RE: Cameron Boundary Line Adjustment, BL-11-00007

Map Number 22-11-09011-0023 Parcel Number 167835  
Map Number 22-11-09011-0024 Parcel Number 177835

Community Development Services is in receipt of the above referenced application. The application has been deemed complete and **preliminary approval** is hereby granted. Pursuant to Kittitas County Subdivision Code Chapter 16, please note the following items must be completed prior to final approval of the administrative segregation and must be submitted to our offices for review:

BL-12-00029 Ellis Master File @ \\Arda\teams\CDS\Projects\BLAs\BL 2012\ BL-12-00029 Ellis

Diagram of Adjustment Request

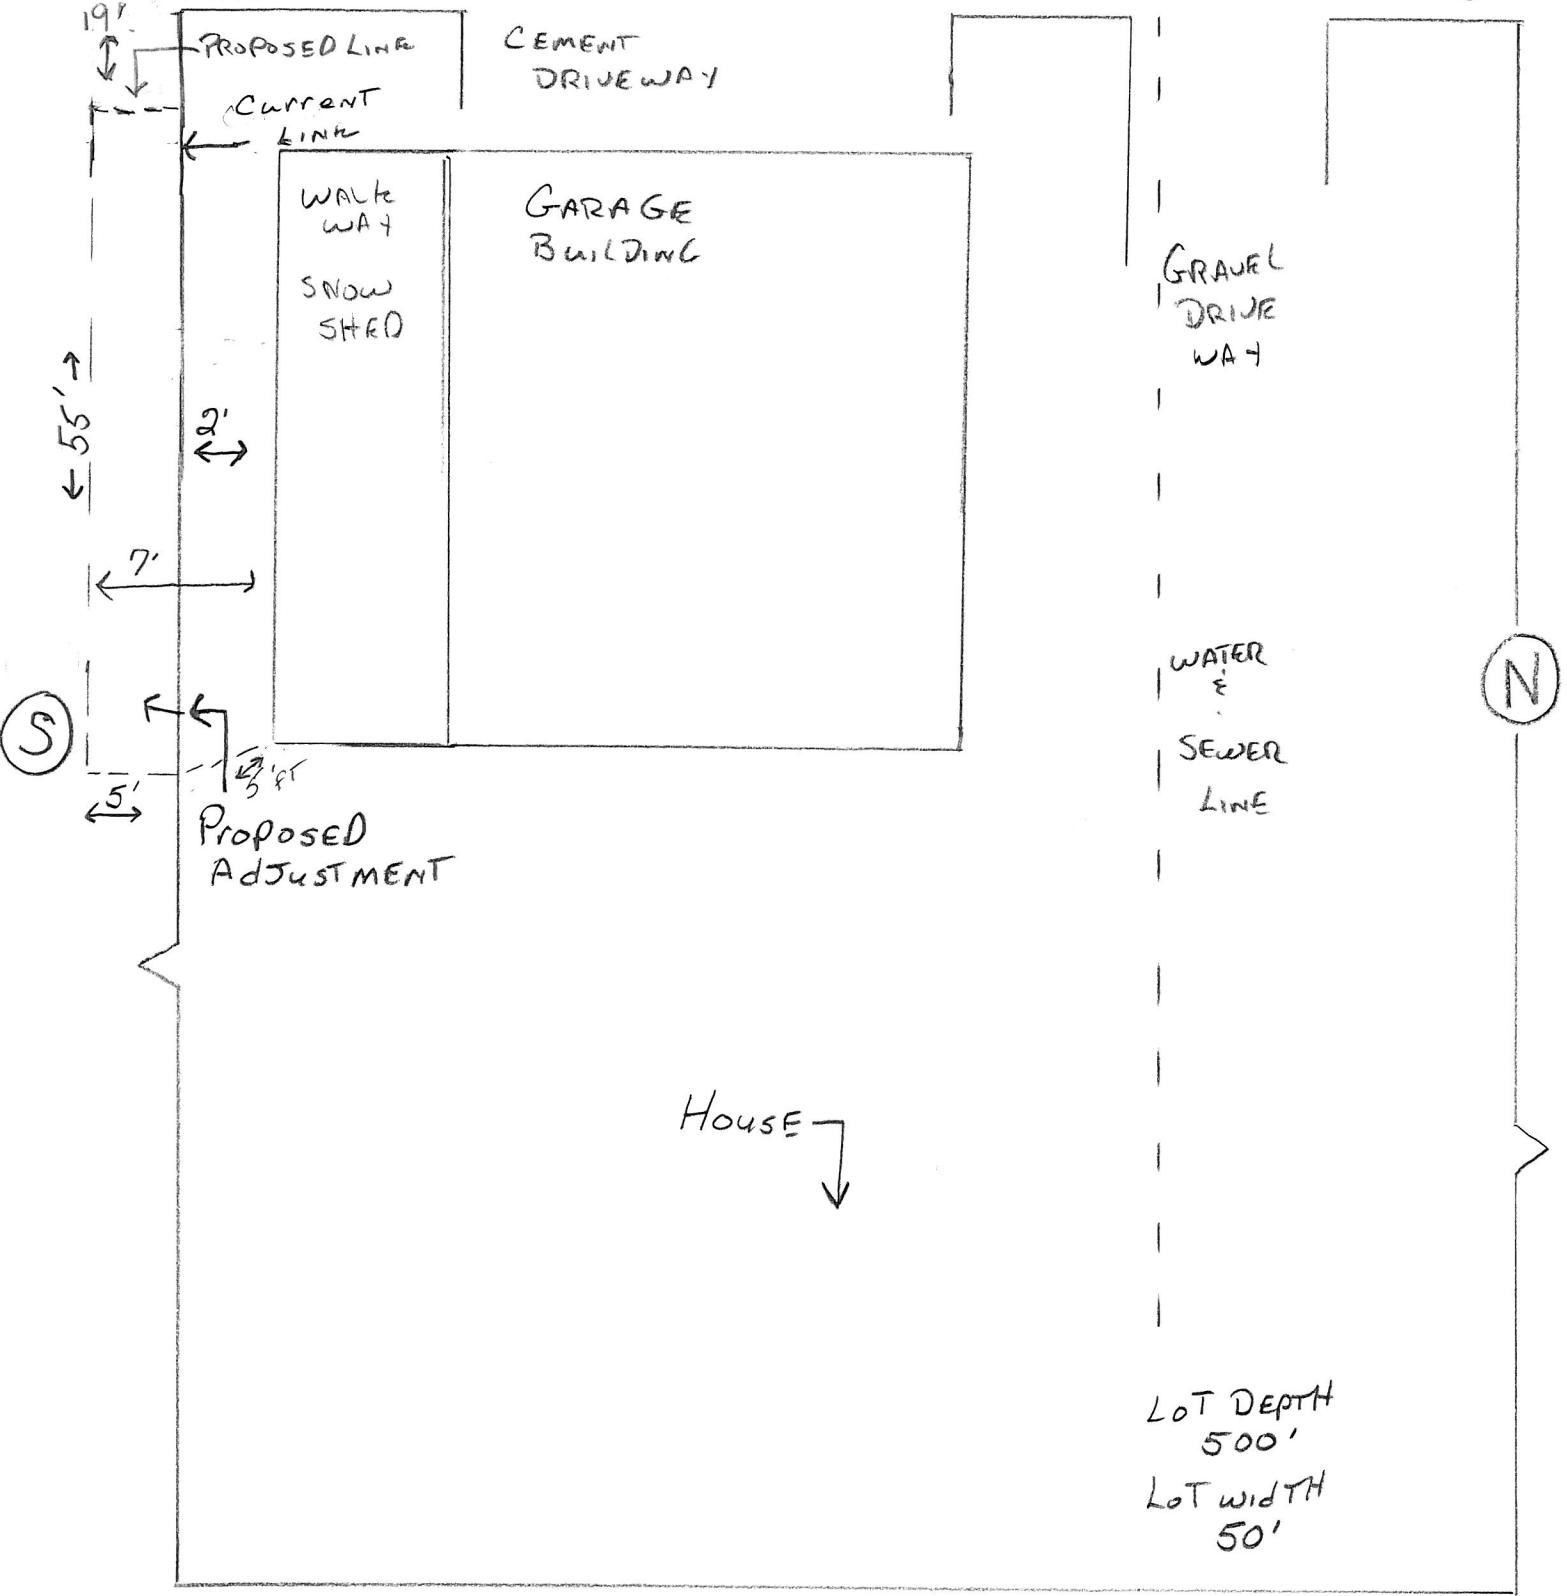
- Ensure that boundary line adjustments do not infringe upon existing structures, to include propane tanks, etc.
- All future development must comply with the International Fire Code.

This looks OK as long as the proposed line doesn't come within 50 feet of an existing well.
